CITY OF ALBUQUERQUE

August 4, 2017

RE: **Campbell Compound**
Drainage Report and Grading Plan
Engineer's Stamp Date 7/21/17
Hydrology File: G13D032

- ### CIVIL GENERAL NOTES
- THE CONTRACTOR SHALL ABIDE BY ALL STATE, LOCAL, AND FEDERAL LAWS, CODES, RULES AND REGULATIONS WHICH APPLY TO THE CONSTRUCTION OF THESE IMPROVEMENTS, INCLUDING EPA AND ADA REQUIREMENTS.

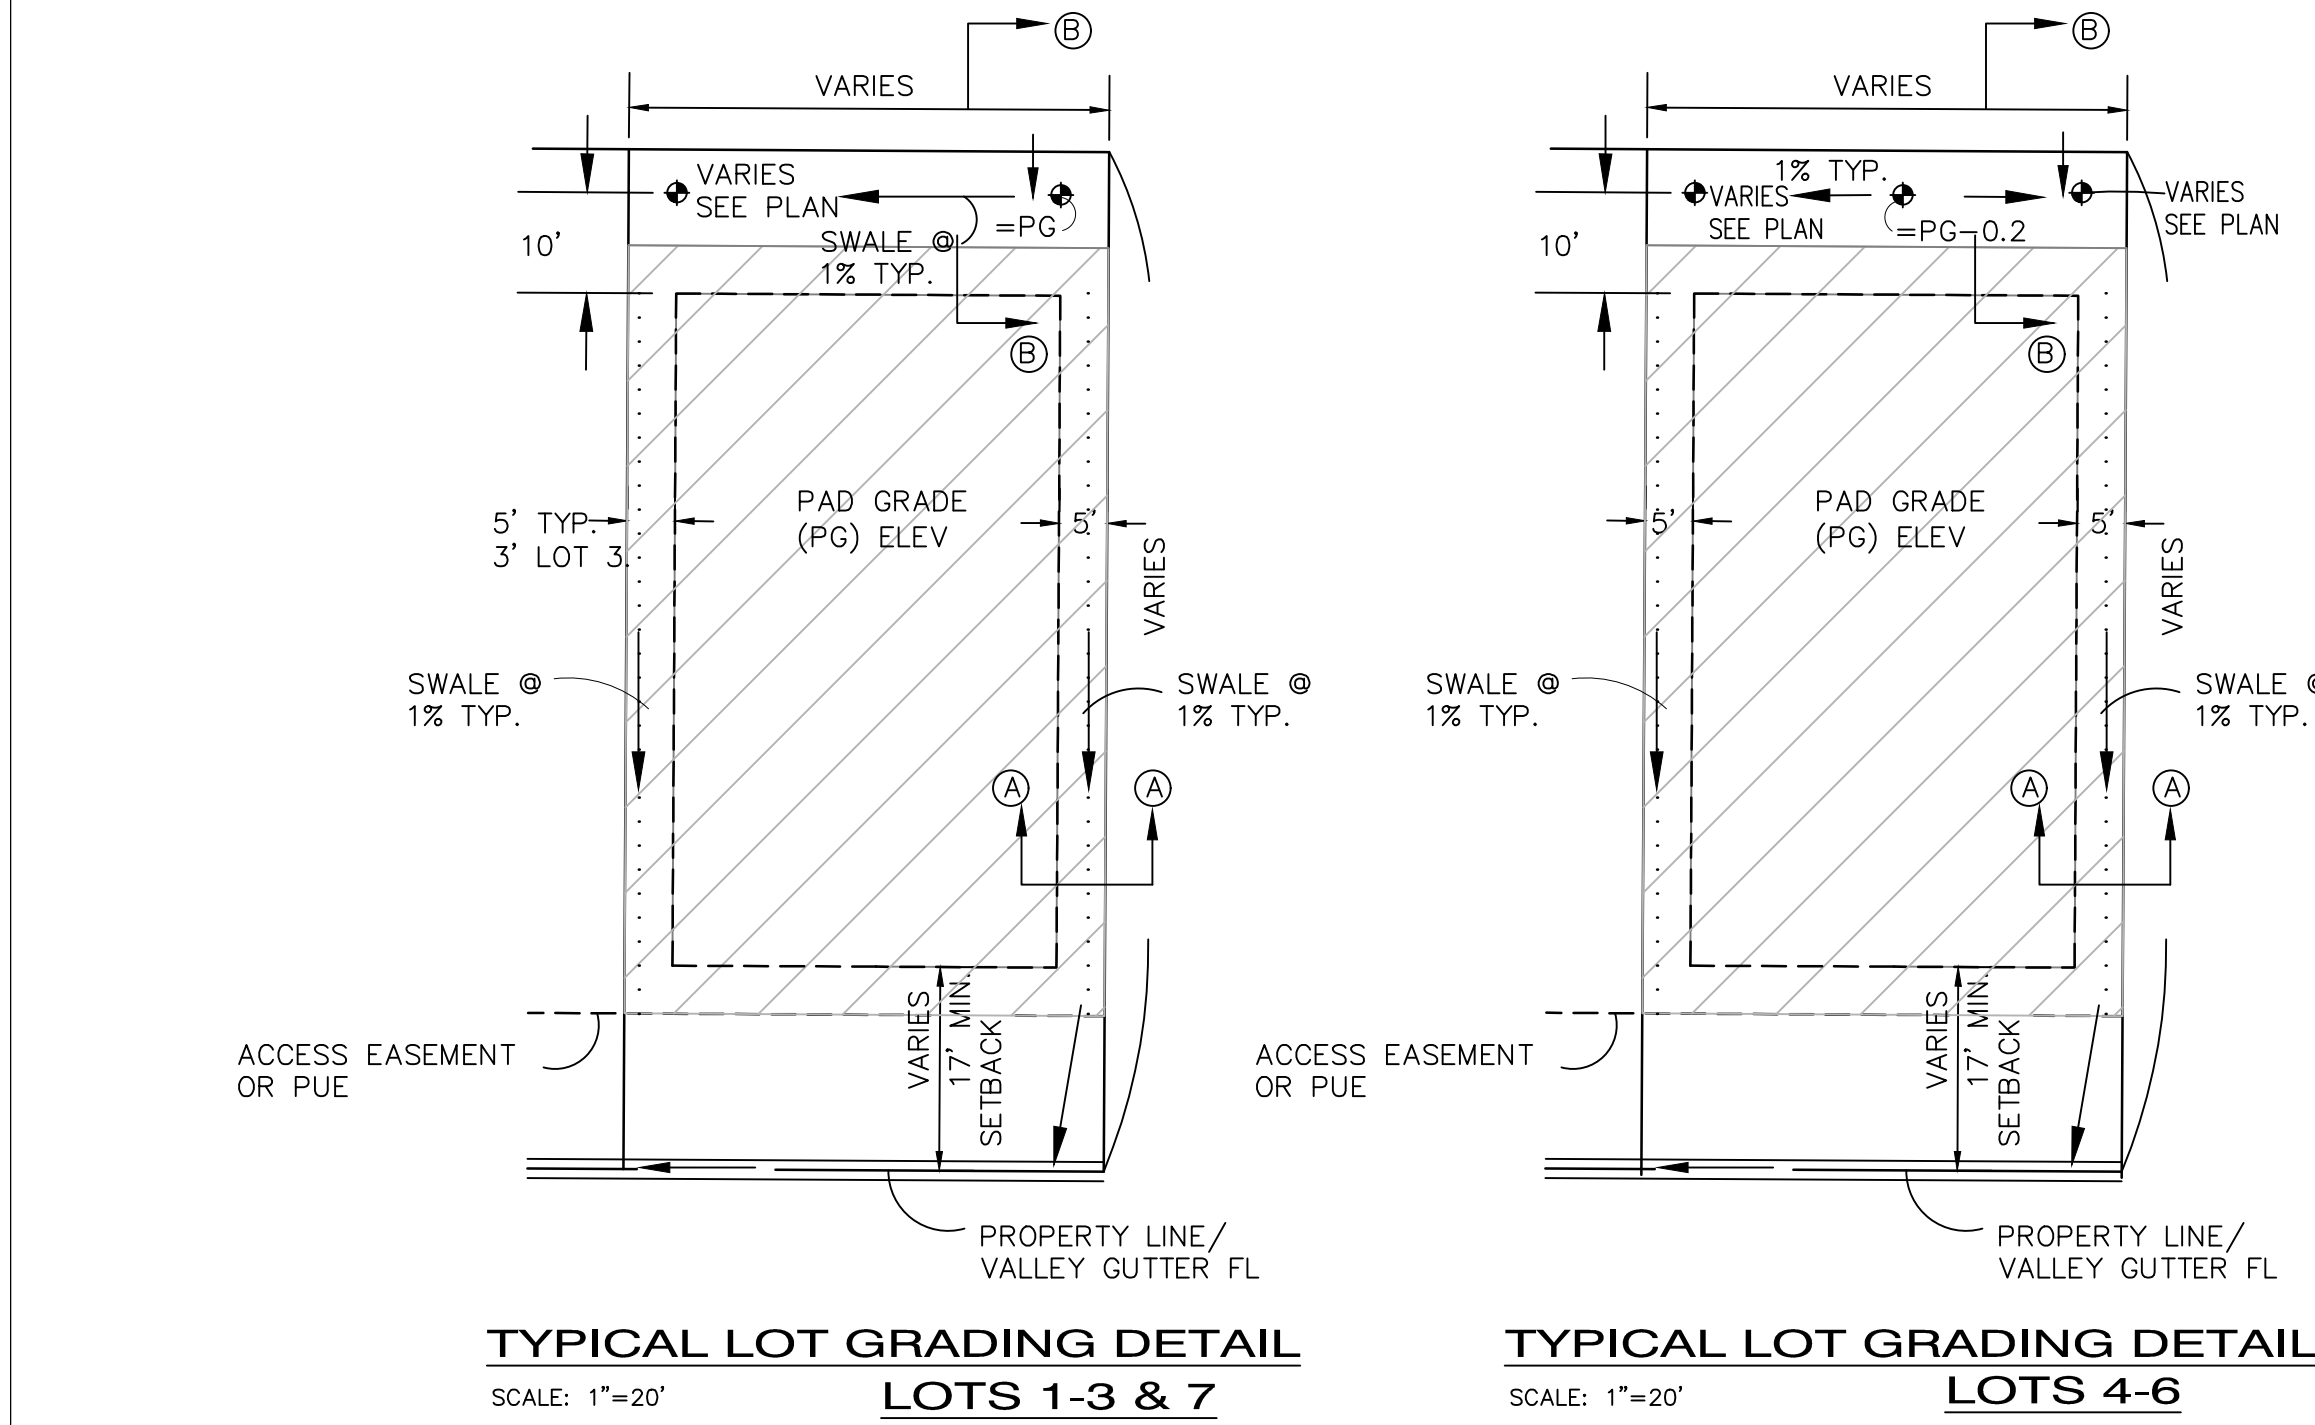
- 6.1. Raising the grade in this subdivision will put it several feet above the Campbell Farms subdivision. Ensure no drainage will exit this project site and impact this adjoining subdivision.
- 6.2. Include a section view though the property line between Campbell Farm Rd and the Campbell Compound east lots.
- 6.3. The backyard walls and footers (Section B-B) will need to be wholly contained on this project's property, unless written concurrence can be provided by the adjoining property owners for common walls.
- 6.4. Show the property line, section cut, and dimensional data for the double retaining wall.
- 6.5. Provide additional dimensions on the wall sections: max height retained, max privacy wall heights, and offsets.

- 6.6. Increase the slope and specify a minimum depth at flowline along the backyard walls; clarify the typical lot grading detail to show the backyard drains to the front (Kayla Ln) and no cross lot drainage or drainage through the backyard wall occurs.
7. Are any easements required for the ditch and will they conflict with the pad or wall locations?
